**Re: EXHIBITION OF STATE SIGNIFICANT DEVELOPMENT
APPLICATION SSD-10389**

PROPOSAL:	LIVERPOOL HOSPITAL REDEVELOPMENT
ADDRESS:	CORNER OF ELIZABETH AND GOULBURN STREETS, LIVERPOOL HOSPITAL

Council refers to its submission made on 1 July 2020 in relation to SSD-10389.

CAMPBELL STREET

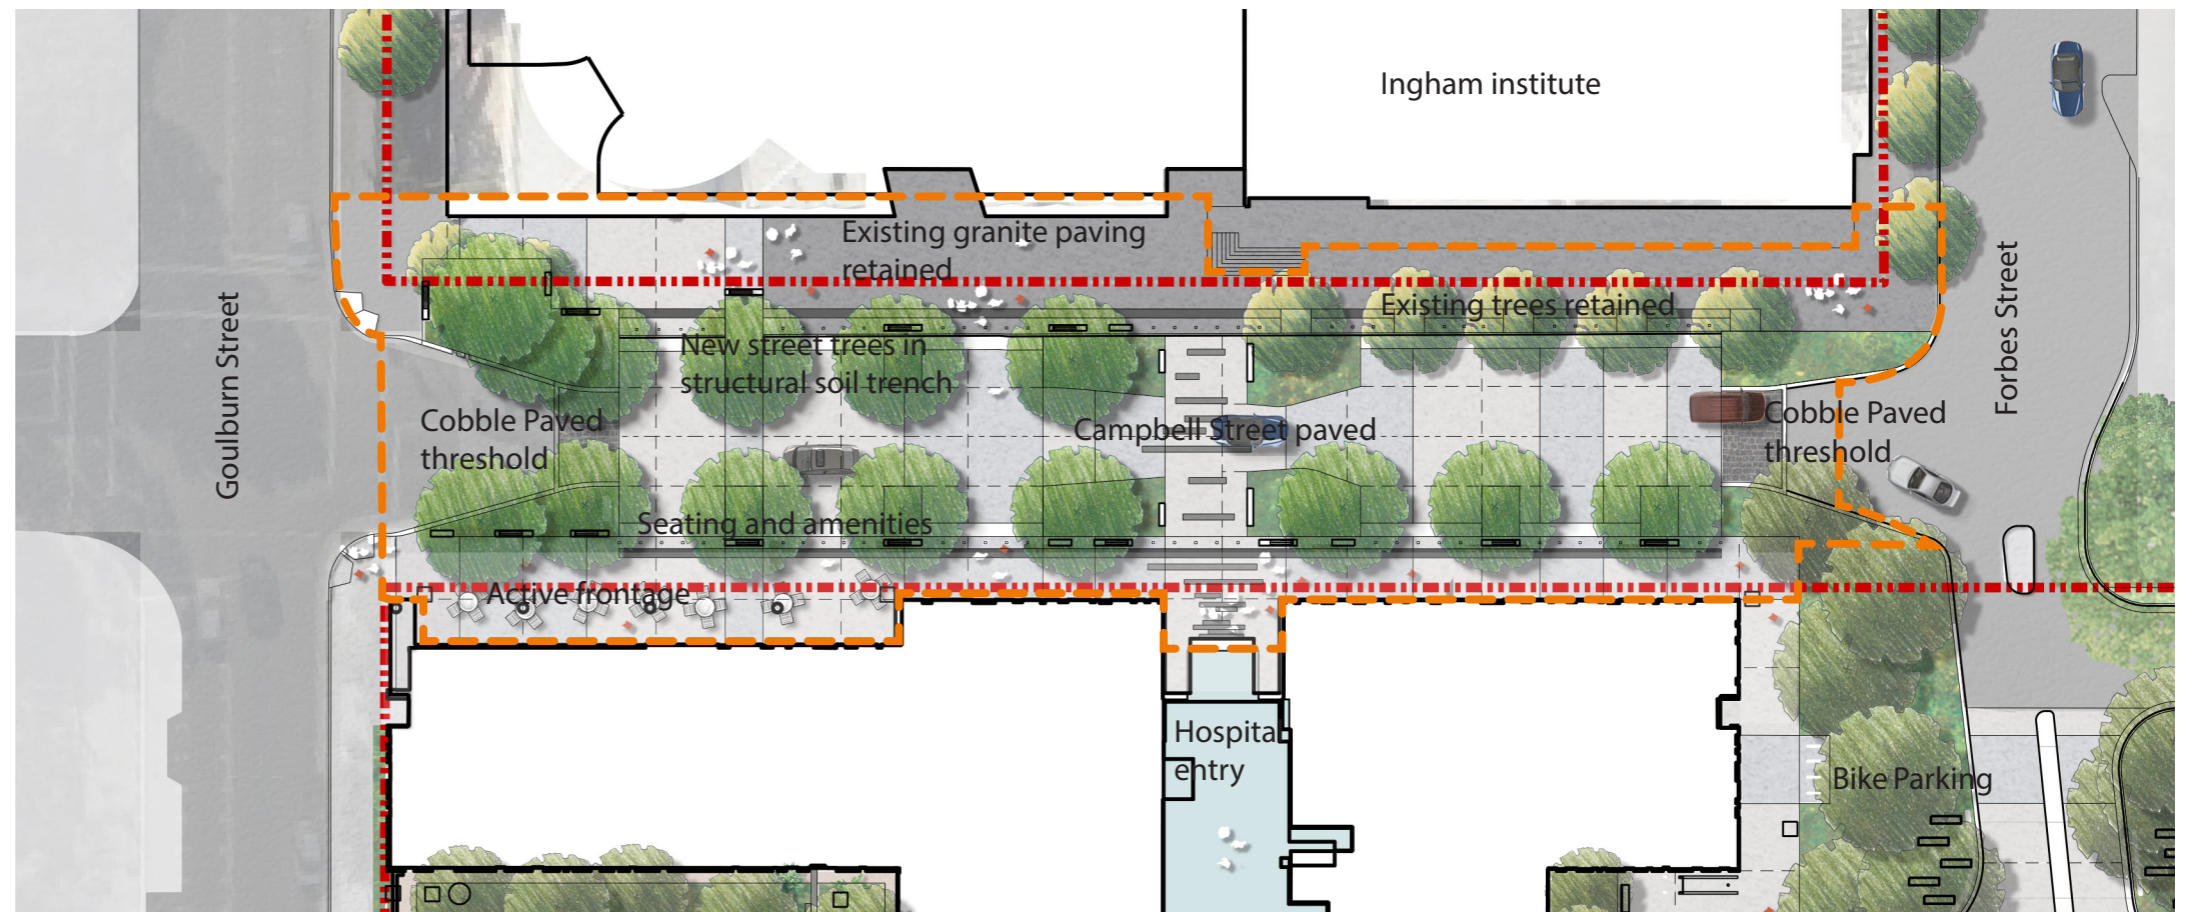
2. As previously discussed, the applicant proposes a 10km/h shared zone along Campbell Street between Goulburn Street and Forbes Street. The original submission provides an outline of the concerns raised by Council's Traffic and Transport Section with this proposal.

Whilst these concerns are still considered to be pertinent to the assessment of the SSD application, it should be noted that Council supports the intended objective of the proposed shared zone to create a more pedestrianised area which complements the active frontage proposed as part of the redevelopment.

Council requests that every attempt is made to address these concerns. However, in the event that shared zone is unachievable in the form proposed, it is recommended that the applicant investigate alternative treatments to the roadway so as to balance traffic concerns with the intended objective of the shared zone.

CORNER OF FORBES AND CAMPBELL STREET

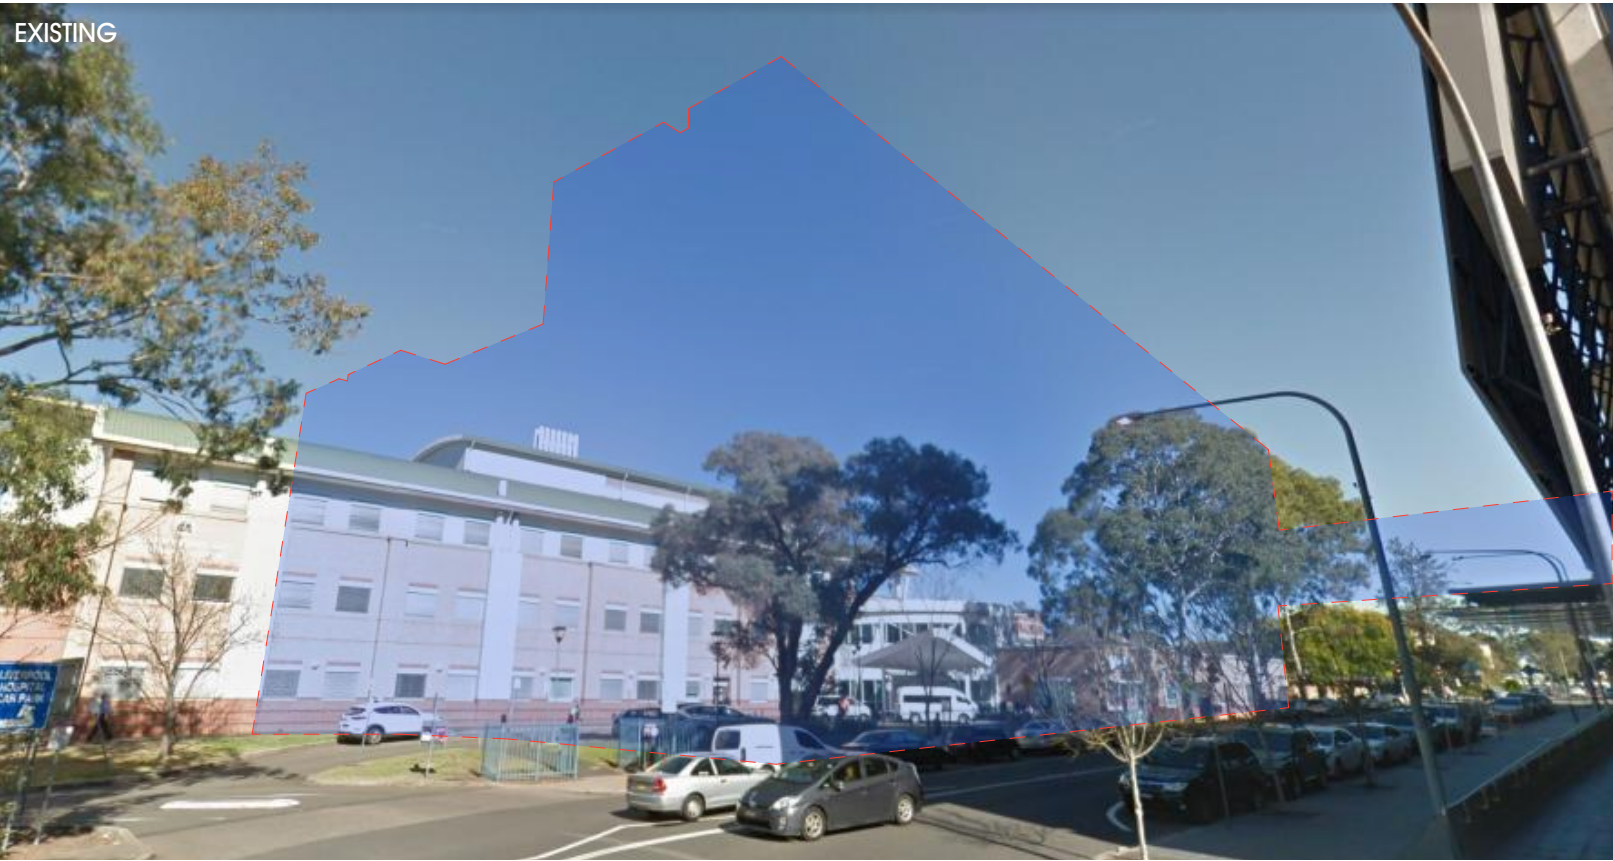
1. Forbes Street/Lachlan Street intersection is an existing four-way intersection with priority sign control. The expected increase in traffic movements would require traffic movements through the intersection to be regulated. It was originally suggested that a condition be imposed for a roundabout in this location so as to regulate traffic at the intersection.

This intersection constitutes part of the Hoddle grid street pattern which is a foundational element of the Liverpool CBD. All development in the CBD is required to be designed in a manner that adequately responds to this key element of the CBD, including roadwork. Upon further consideration, it is

considered that roundabouts are not considered to be roadworks that are sympathetic to the grid street pattern.

Whilst Council maintains that treatment is required here to regulate the expected traffic movements, the installation of roundabouts so as to remedy this situation is discouraged. Council requests that the applicant investigates an alternative treatment that satisfactorily regulates the design of the intersection whilst improving the streetscape and pedestrian permeability.
